PLAN REVIEW SHEET

Date: August 24, 2020

Petition #: RZP 2020-094

Address: Perimeter Pointe Parkway

SITE PLAN  
 RZ1

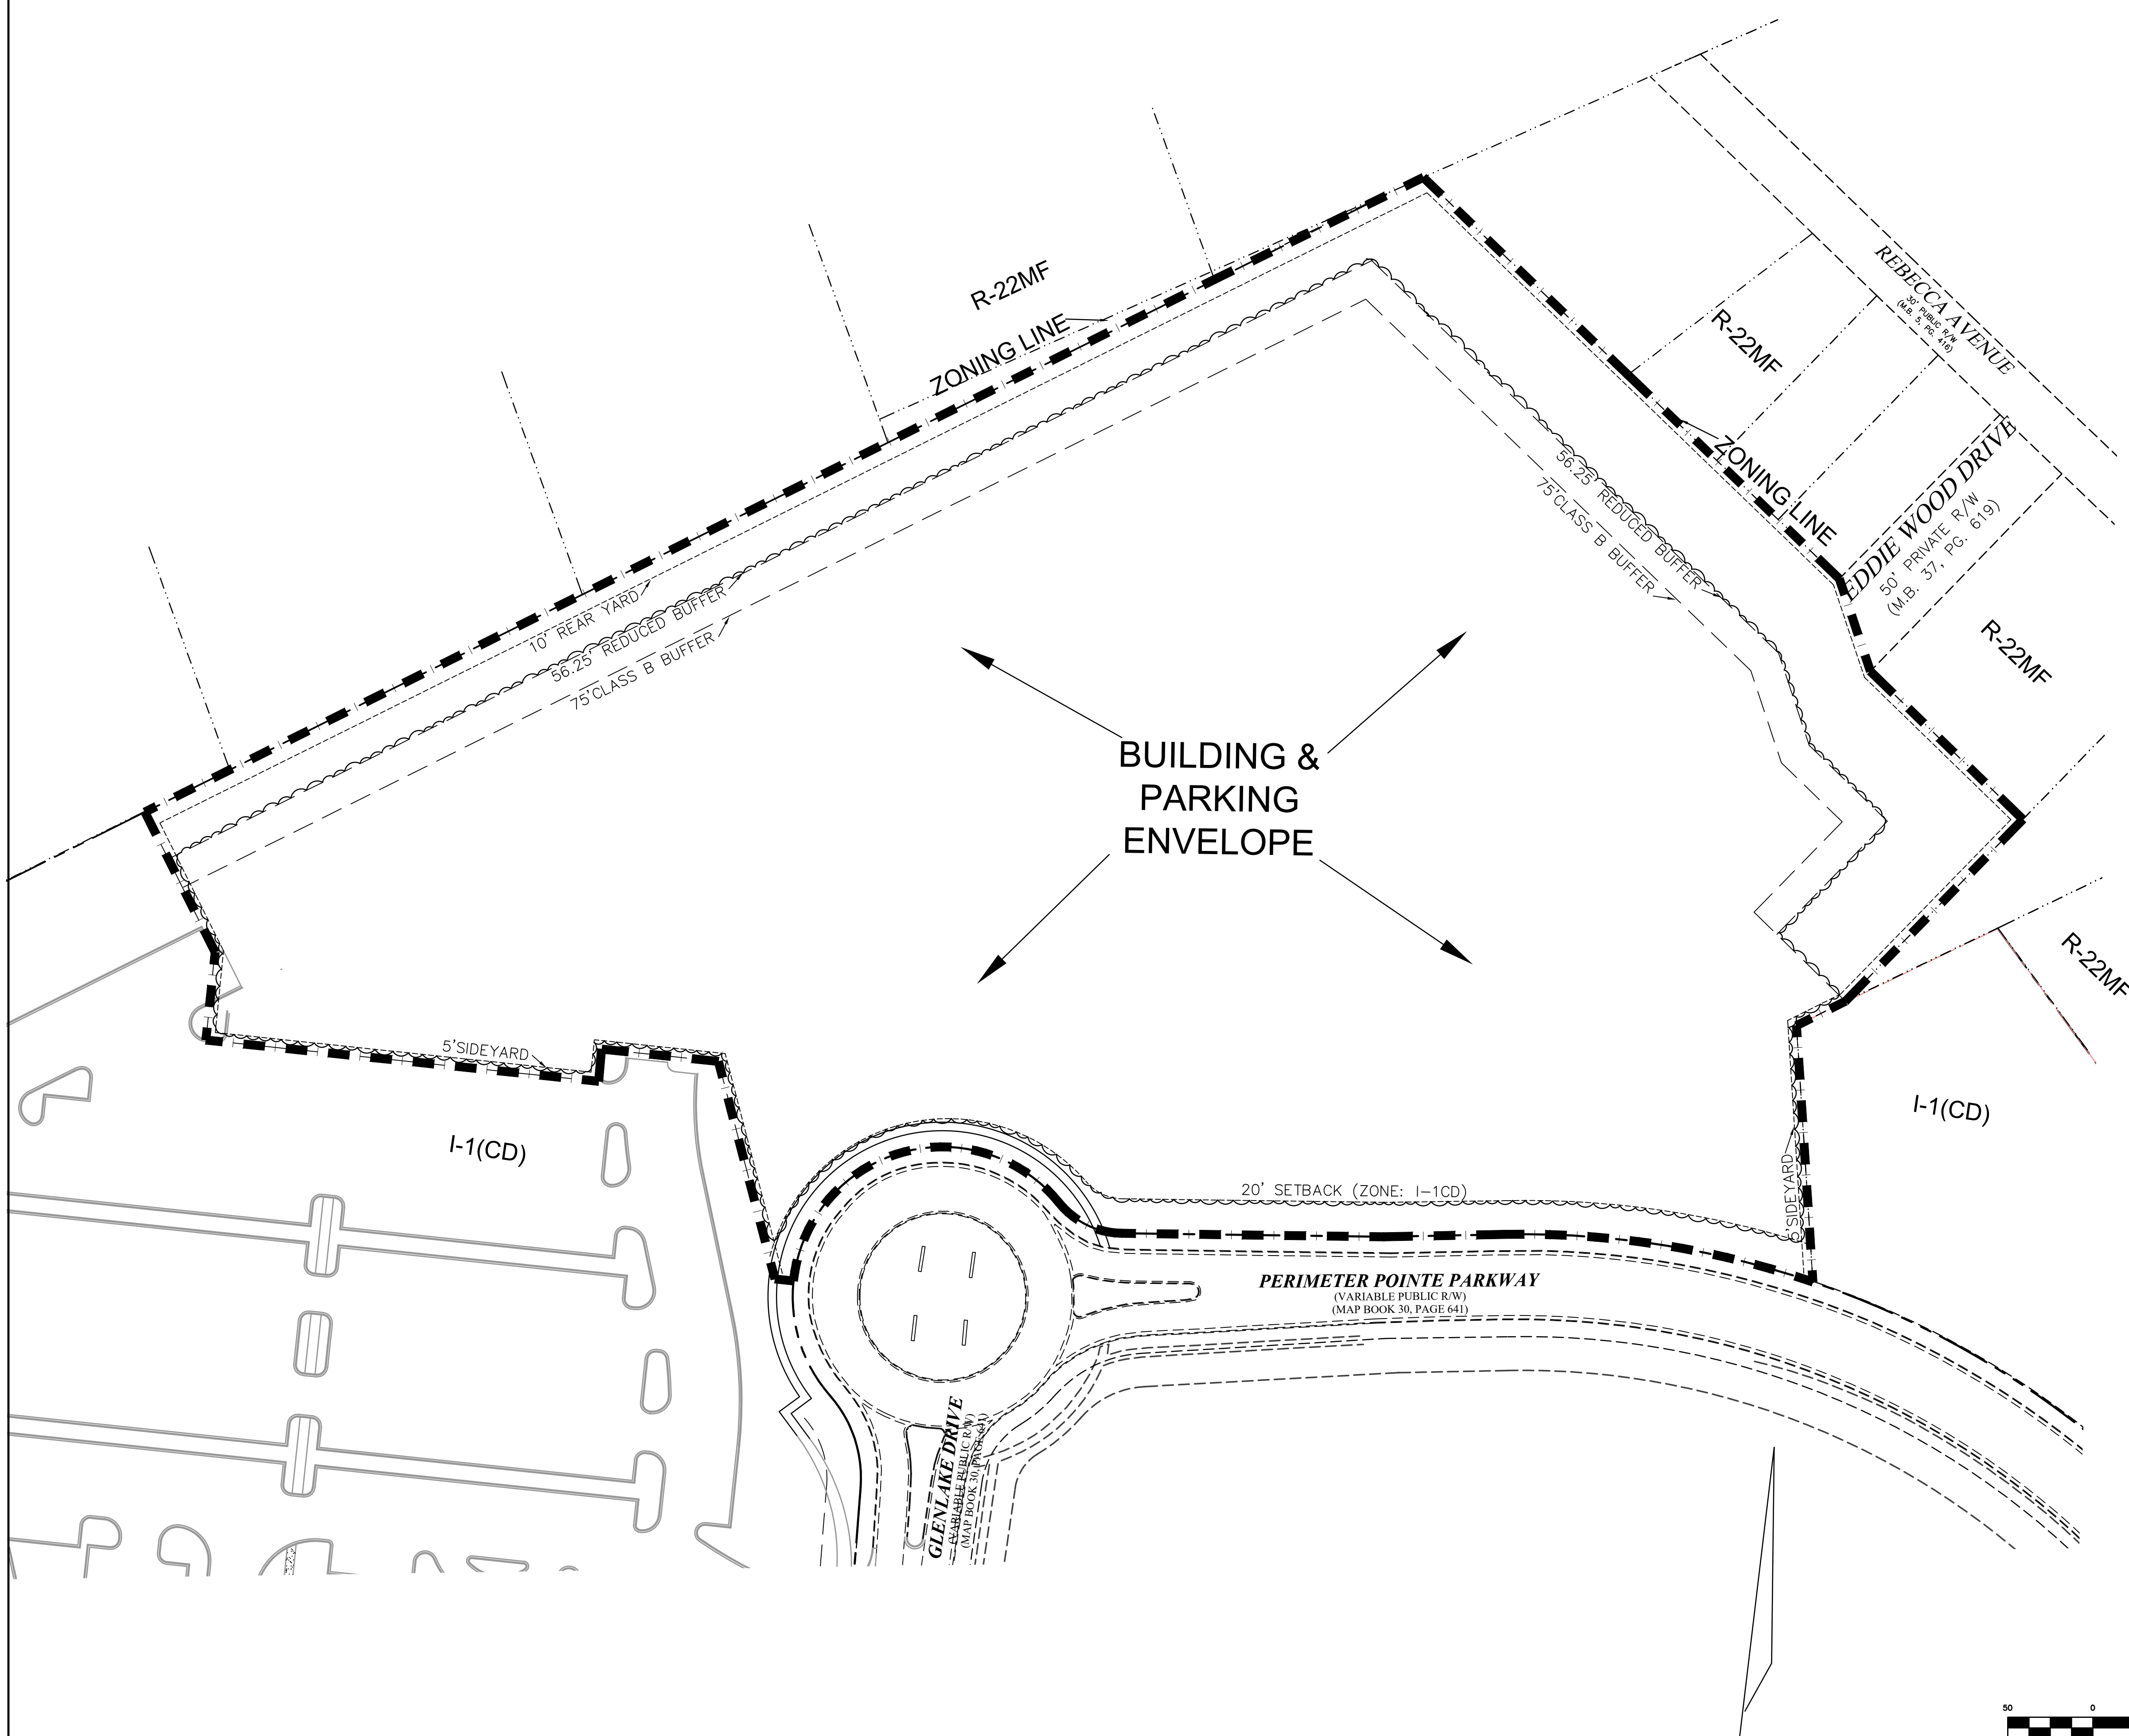
The site is located near CATS local bus route #60 along Tyvola Road where it currently serves the Veterans Hospital across the street. CATS intends to extend service to Perimeter Pointe Parkway and requests the developer to construct an ADA compliant bus waiting pad per Land Development Standard #60.01A. CATS will coordinate with CDOT regarding bus stop ridership to consider pedestrian refuge at Tyvola Rd and Cascade pointe Blvd. The final location of the pad will be coordinated with the developer through the permitting process.
